DRB CASE ACTION LOG

DRB Application No.: 04DRB-00323 ^{3P}	Project # 1002472
Project Name: COURTYARDS @ ALAMEDA	Phone No.: 248-3477
Agent: Adil Rizvi

**CITY OF ALBUQUERQUE
PLANNING DEPARTMENT
Development Review Board
March 17, 2004 Comments**

RE: Courtyards at Alameda, Noreste Addition/final plat

Final Plat of Courtyards at Alameda

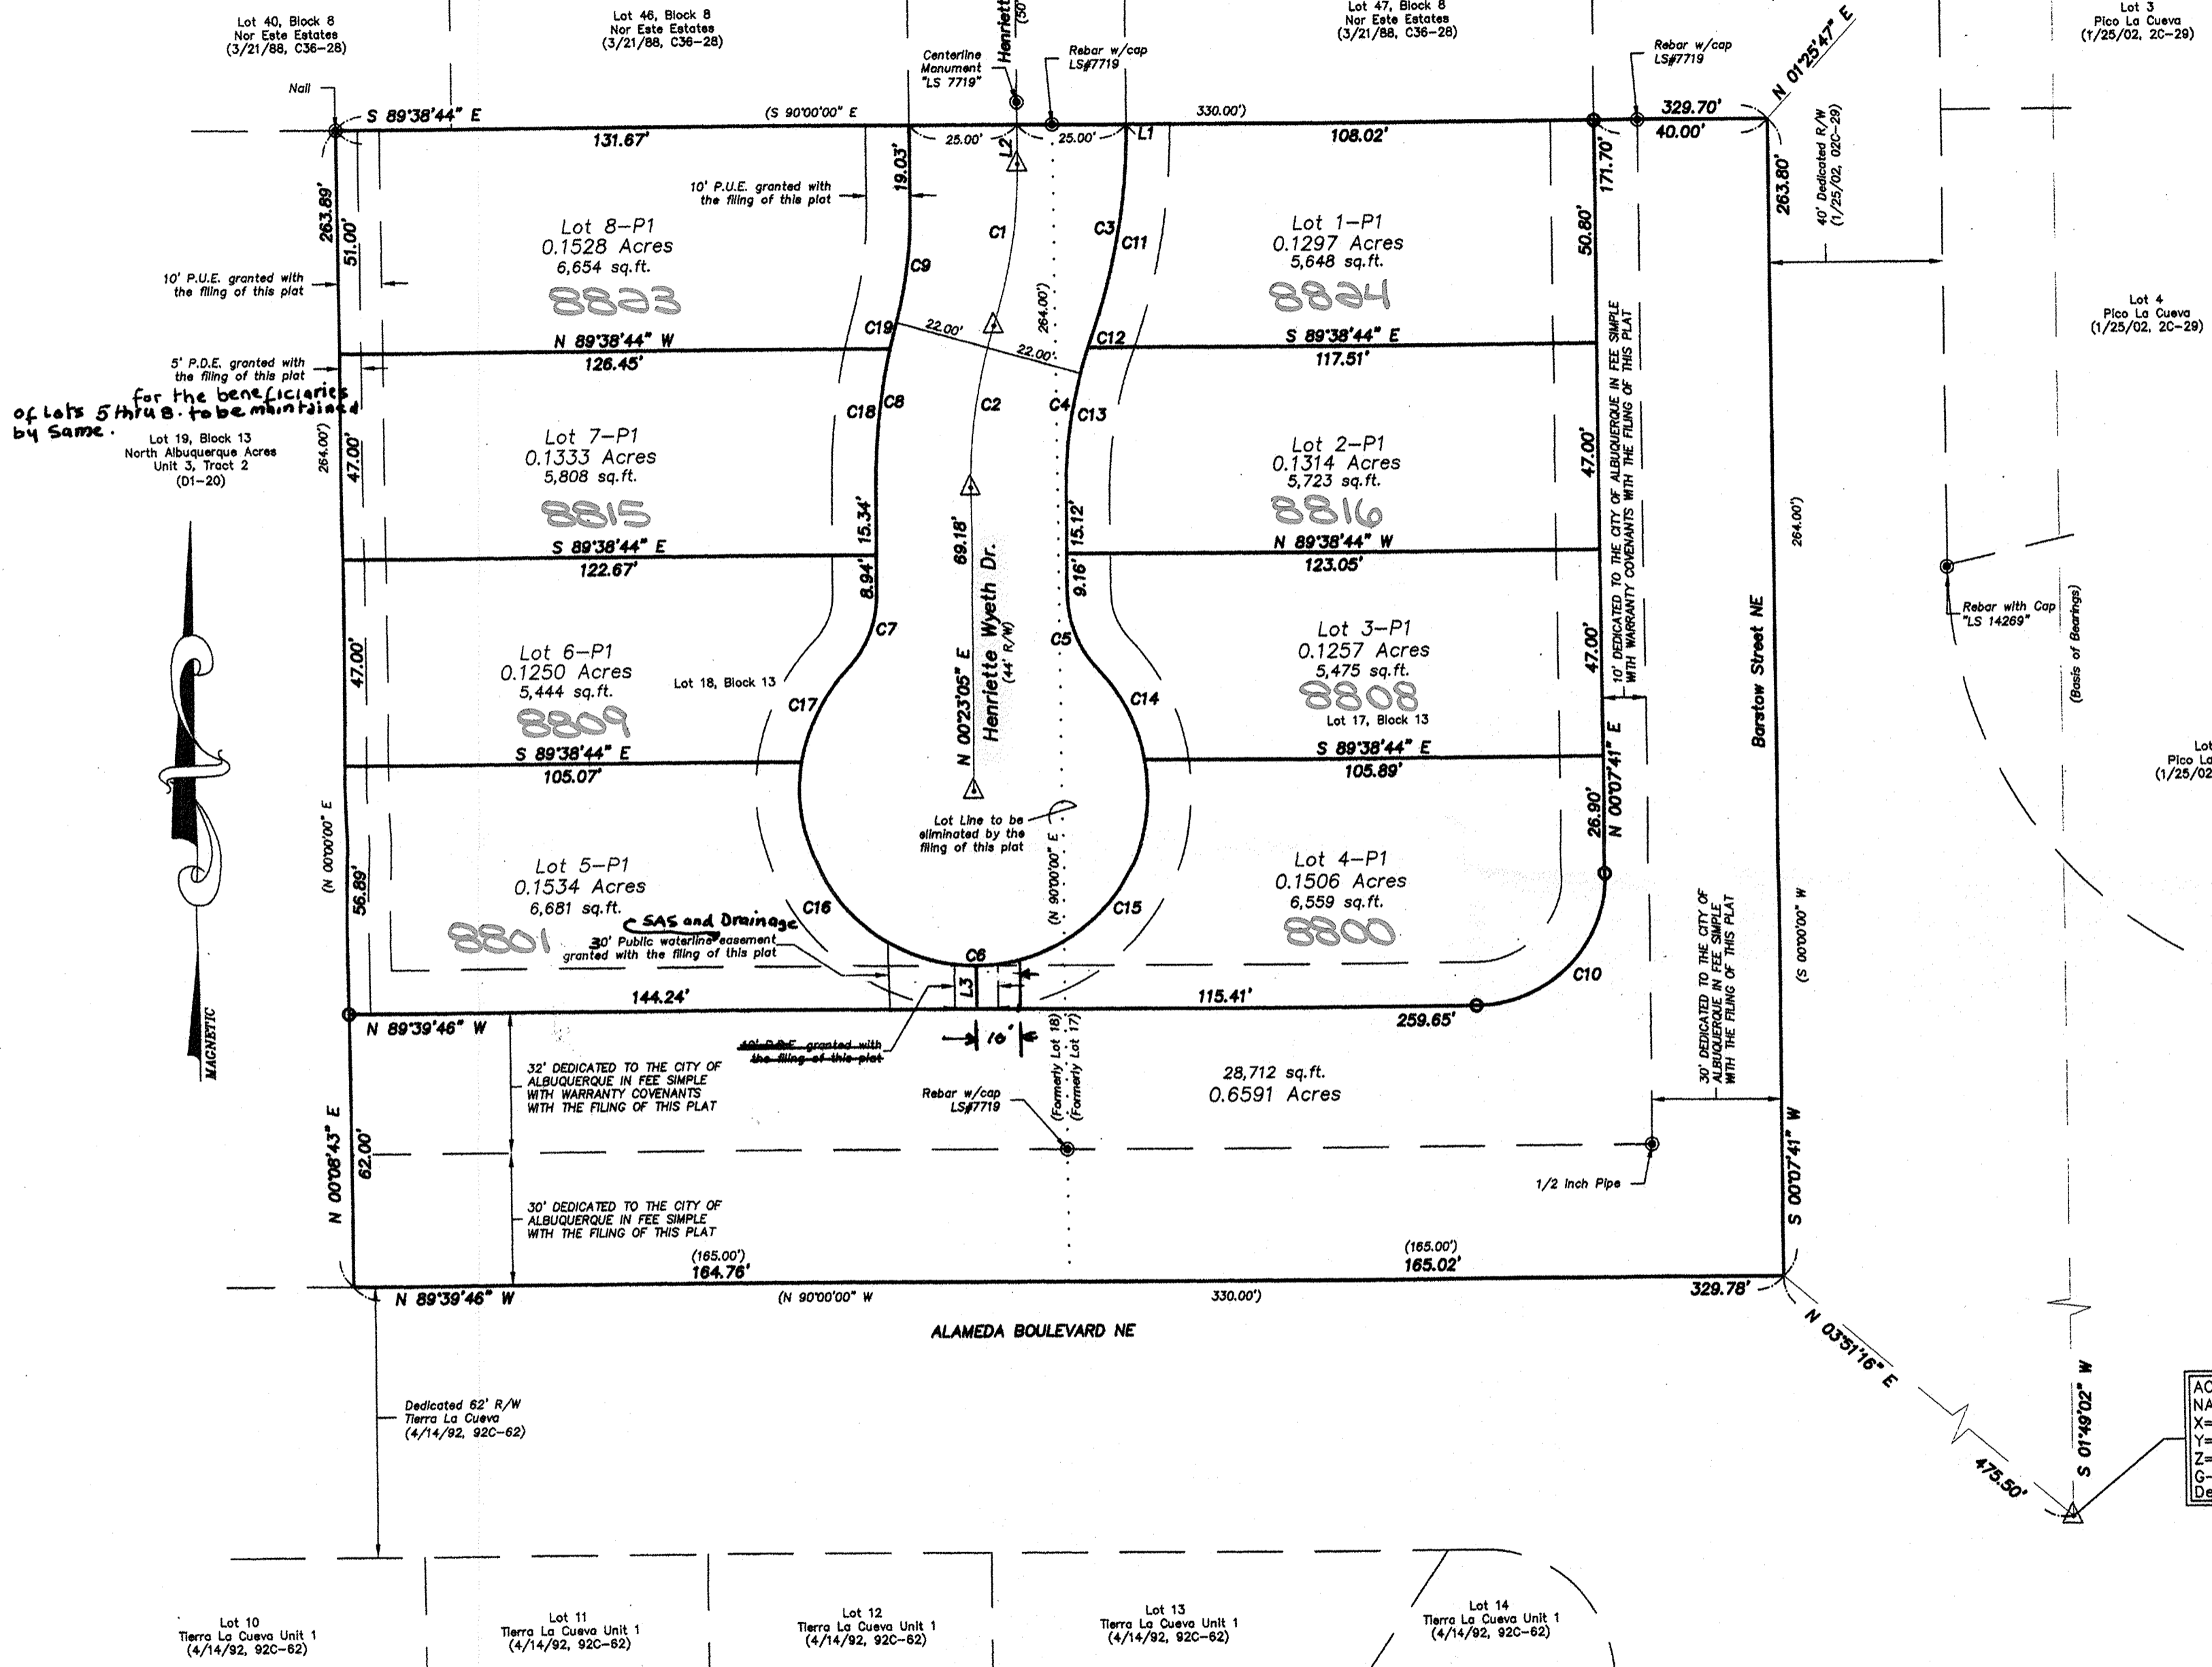
- UTILITIES: Addition of SANITARY SEWER EASEMENT
 - _____
 - _____
 - _____
- Signed by RG. 3/18/04

- CITY ENGINEER / AMAFCA: Pvt esmt w/ M + B
 - _____
 - _____
 - _____
- Pt. Jr Brad. 3-18-04
Blb 3/18/04

On 3/26/03, when DRB approved the preliminary plat, a condition of final plat was:

“The private drainage easement on the west side of the subdivision
should have the maintenance & beneficiaries stated on the final plat.”

Was this condition fulfilled? Planning did not find this note.
